Appendix C – Detailed Response to Submissions

Item	Issue Raised	Comment
Department of Planning, Housing and Infrastructure (DPHI)		
Wran Building Materiality		
DPHI1	Provide a clear rationale for the extent of demolition proposed to the Wran building, including any analysis undertaken that considered alternative approaches.	<ul style="list-style-type: none"> The Wran building and adjacent Galleria have been extensively modified since first opening of the museum in 1988. Originally designed as the front door and shop, the Wran Building now houses exhibition spaces following works in 2011-2013, with the museum entrance on the southern façade. The resulting exhibition space does not provide the internal environment suitable for modern museum practice with insufficient light and acoustic separation and intrusion from internal columns and mezzanine offices. The recladding of the Wran façade will improve the environmental and amenity performance of the exhibition space, by particular, improving acoustic and light control. The removal of columns and mezzanines (that are no longer required for office space) will further create the necessary flexible flat floor exhibition space that the mu

project	POWERHOUSE ULTIMO REVITALISATION 500 Harris Street Ultimo NSW 2007 Australia
drawing	WRAN AND GALLERIA SECTION
drawing no.	A.DA9001
issue	Rev A

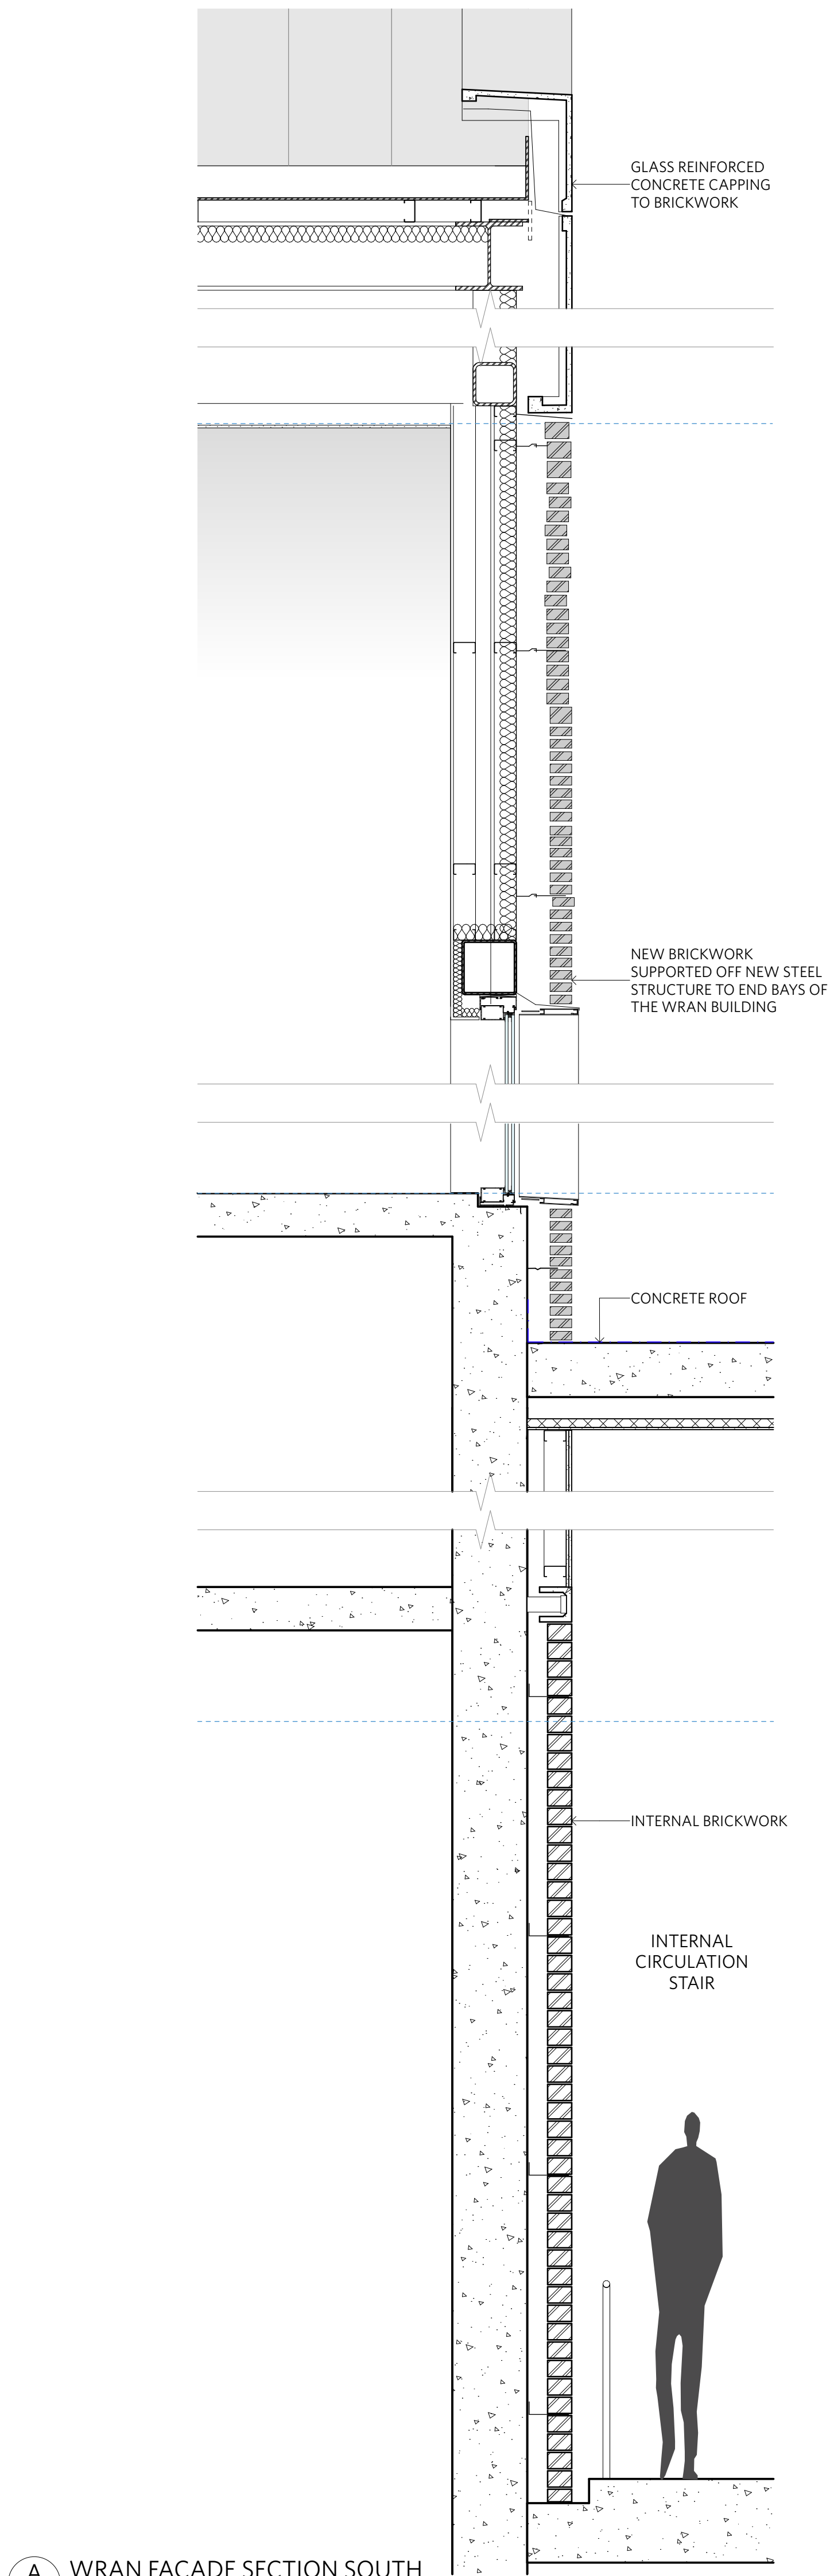
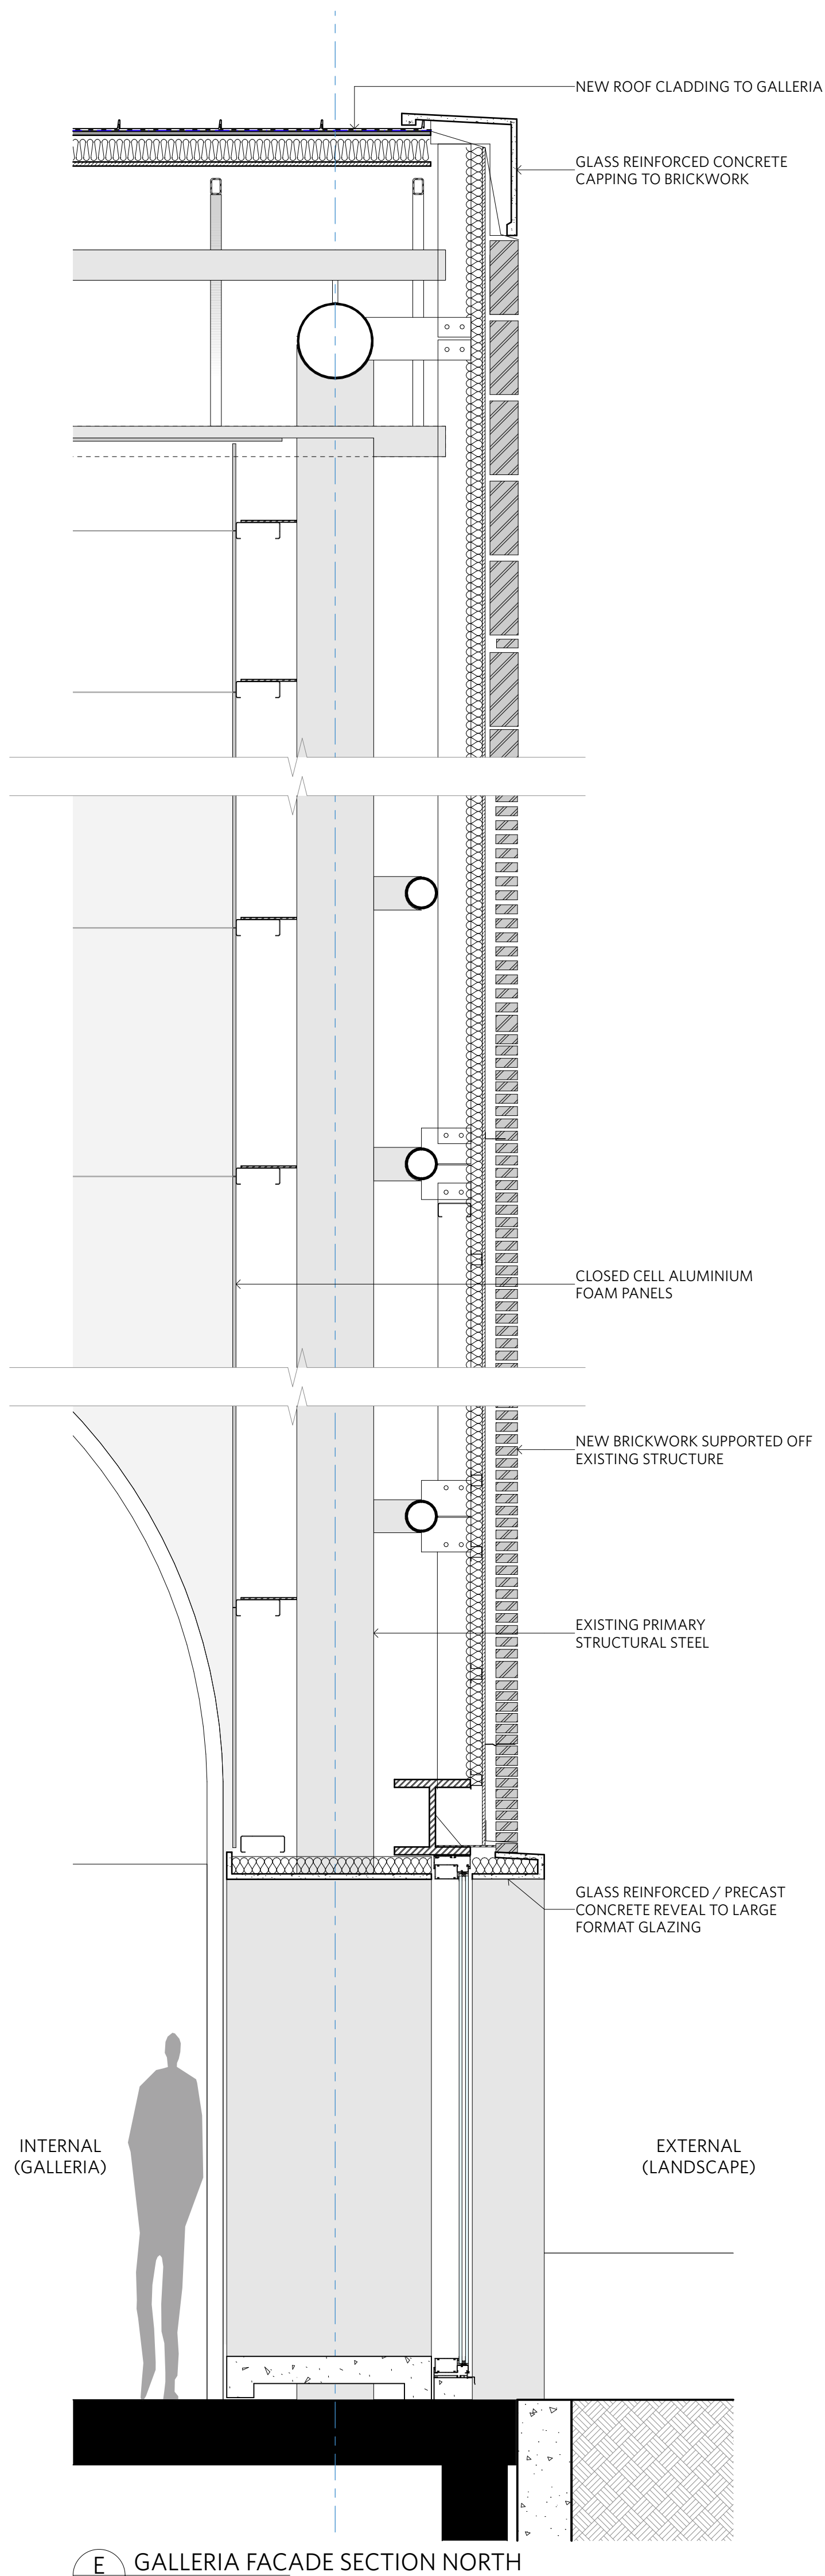
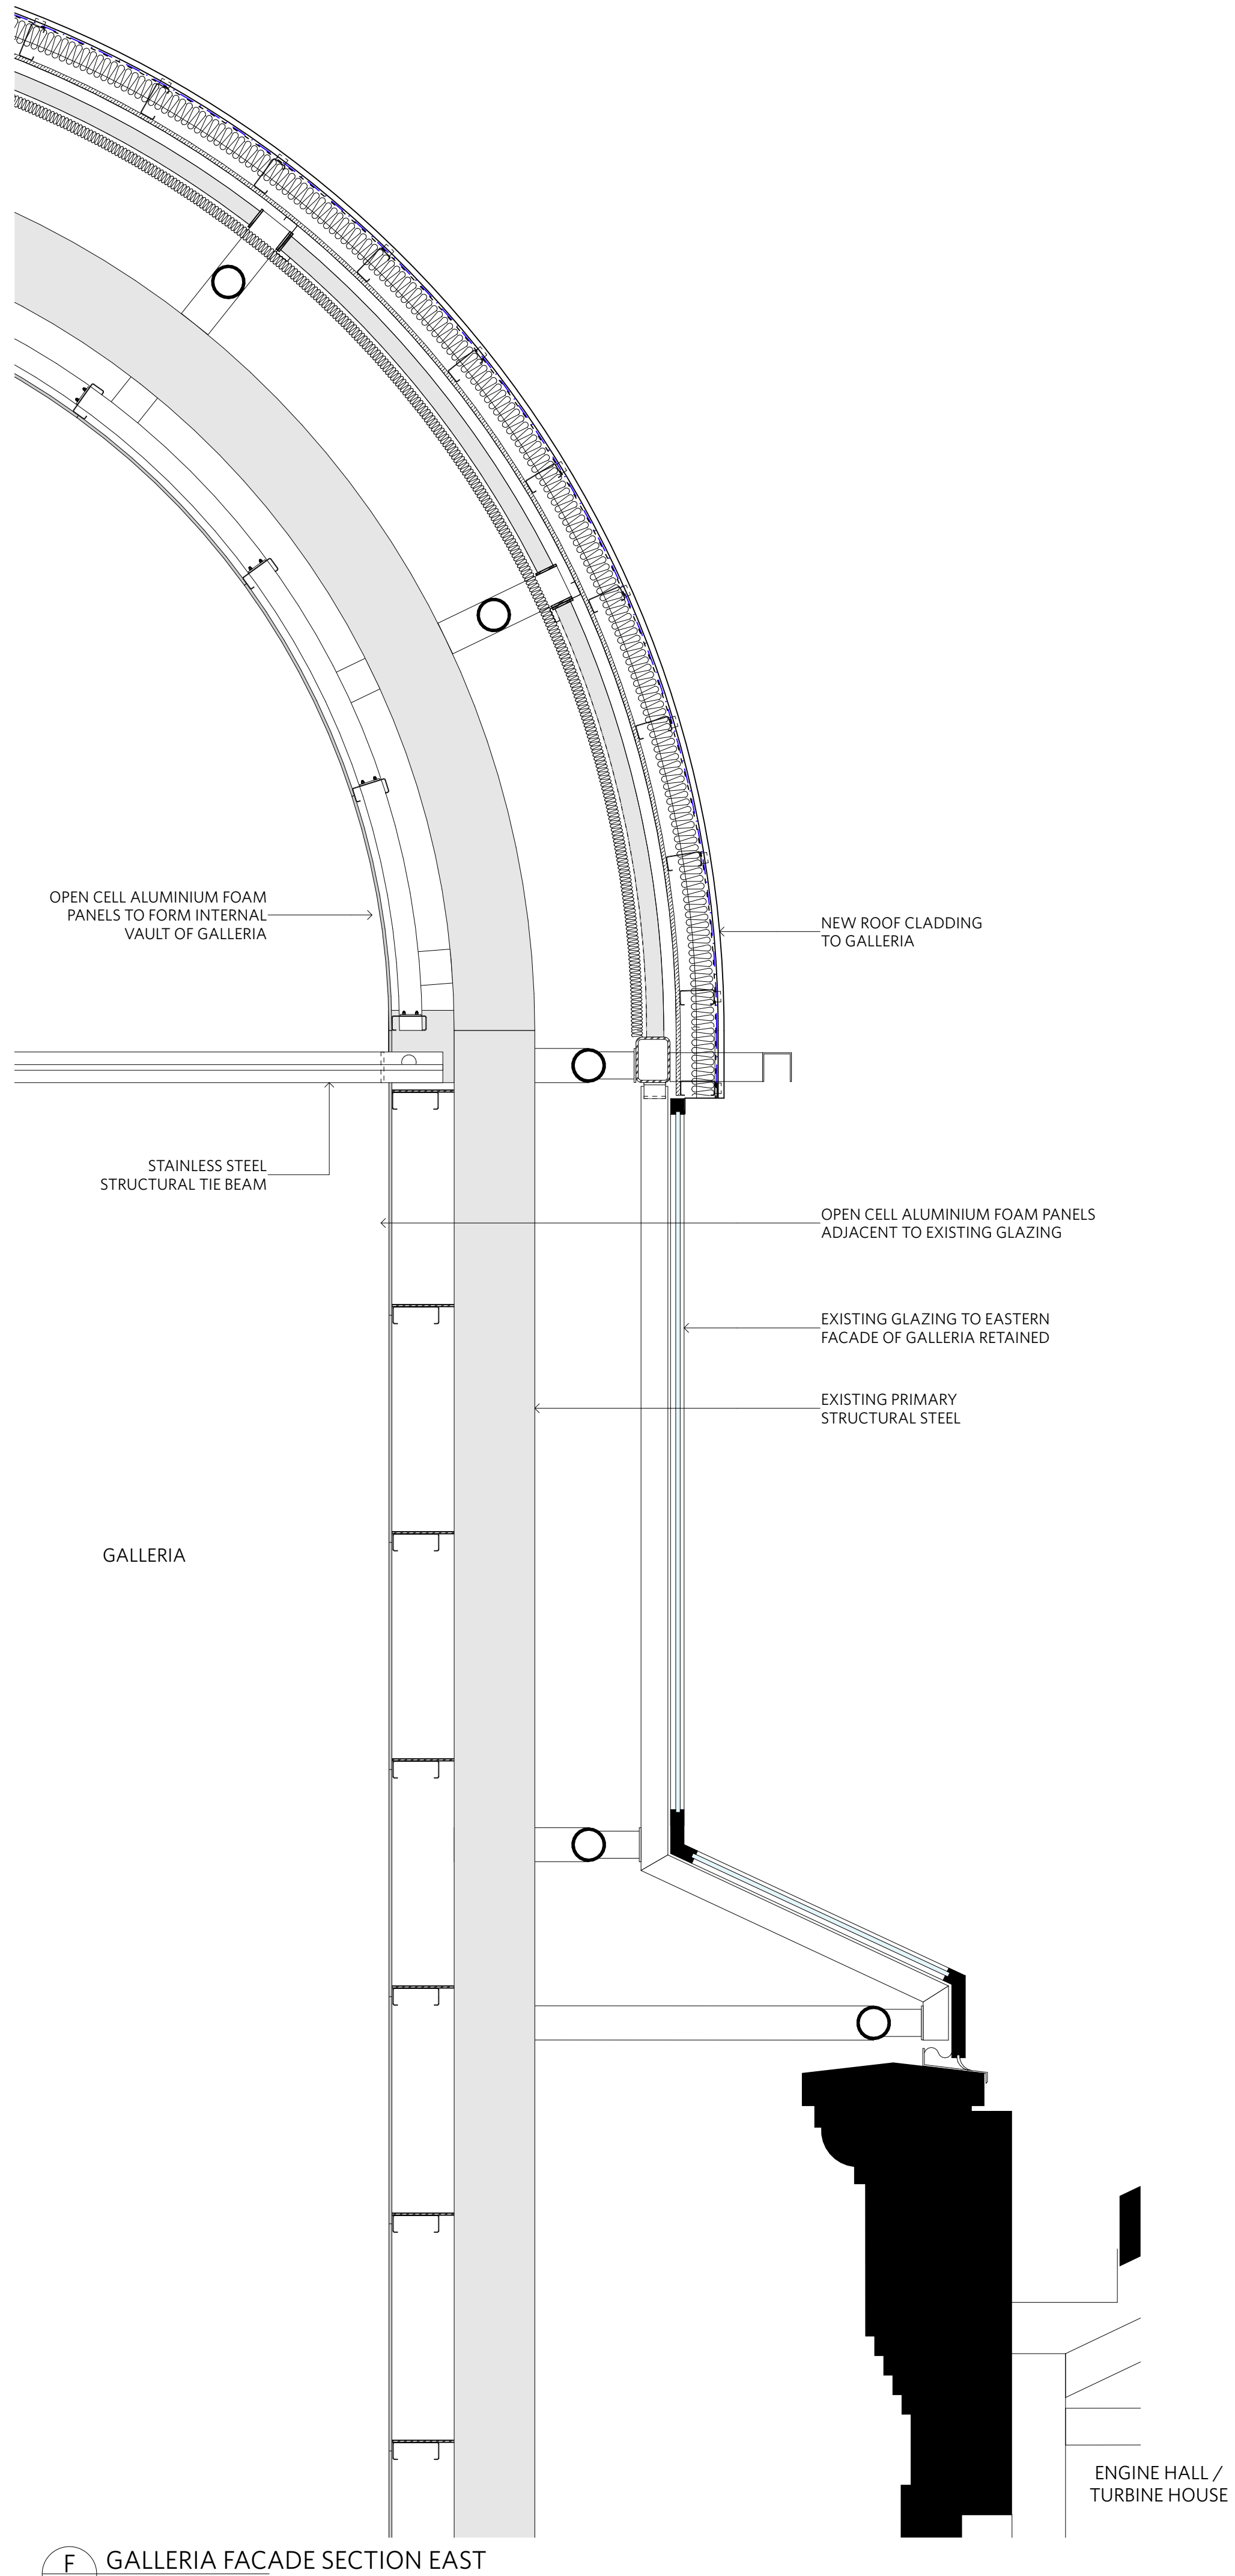
Urban Design		
Legibility of the 'front door' from the Goods Line		
CoS12	The landscape plans show a more legible path of travel to the main entry door from the Goods Line. However, it is encumbered with chairs and tables.	Noted. The Proponent is willing to accept a condition of this nature.
CoS13	Whilst there is no objection to the terrace being a multi-purpose space, it is recommended that the main path of travel from the main door to the Goods Line is clear of any obstructions, providing for direct and clear pedestrian flow that is clearly demarcated.	Noted. The Proponent is willing to accept a condition of this nature.
Wran Building		
CoS14	There is insufficient detail provided on the retained existing structure and the ends of the Wran Hall and the Galleria. The ends are capped in concrete with an infill of brick. It is not clear if the proposed brick ends are self-supporting or supported from the retained existing structure. A detailed 1:20 section through the proposed brick infilled ends of the Wran Building and the Galleria is required.	The requested 1:20 section is included at Appendix E .

CoS15	There is also insufficient information on the internal cladding of the Wran Building and the Galleria. Previously, the design suggested a brick vault. The Amended Design Report now suggests that the Galleria is re-lined with the aluminium foam in panels of varying porosity depending on its location and function within the Galleria. Detailed 1:20 sections are required to	The requested 1:20 section is included at Appendix E .

better understand the materiality of the internal spaces and the extent of use of the aluminium foam to allow light into the Galleria.	
CoS16	The creative spaces along Harris Street are now 2 storeys, with the higher floor to ceiling height being on the 2nd storey. If part of the creative space function is to create artworks, then the floor to ceiling heights may limit the scale and size of the works created.	The revitalisation of Powerhouse Ultimo has considered the requirements of the museum to create and construct exhibitions including artworks. The creative studios can sufficiently accommodate a variety of artwork types and expressions. The creative studios have the potential to incorporate flexible solutions to accommodate a variety of artwork forms and sizes.
CoS17	The Harris Street elevation has a slight projection at approximately 2.6m above the footpath. This is a minor encroachment and neither high enough to satisfy Section 3.2.4 Footpath awnings nor Schedule 4 of the Sydney DCP 2012 and may be at risk of damage.	<p>Noted. It is recognised that the projection at 2.6m above the footpath does not comply with Section 3.2.4 Footpath Awnings or Schedule 4 of the Sydney DCP 2012 due to its height above ground level. However given the project is State Significant, the Sydney DCP 2012 does not apply, as per section 2.10 of the <i>State Environmental Planning Policy (Planning Systems) 2021</i>.</p> <p>The projection has been designed as an architectural capping element to assist in articulating the façade, and is only 125mm in depth. The DCP provides for projections up to 450mm, which is over three times the size of the proposed projection on Harris Street.</p> <p>Whilst the DCP provides for these projections to be height of 3 metres, 2.6 metres above ground is sufficient for an architectural articulation feature of 125mm in depth. Further, the Proponent is comfortable that the feature will not be subject to damage as it does not abut the roadway (for damage by vehicles) and is well behind the line of the street trees.</p>
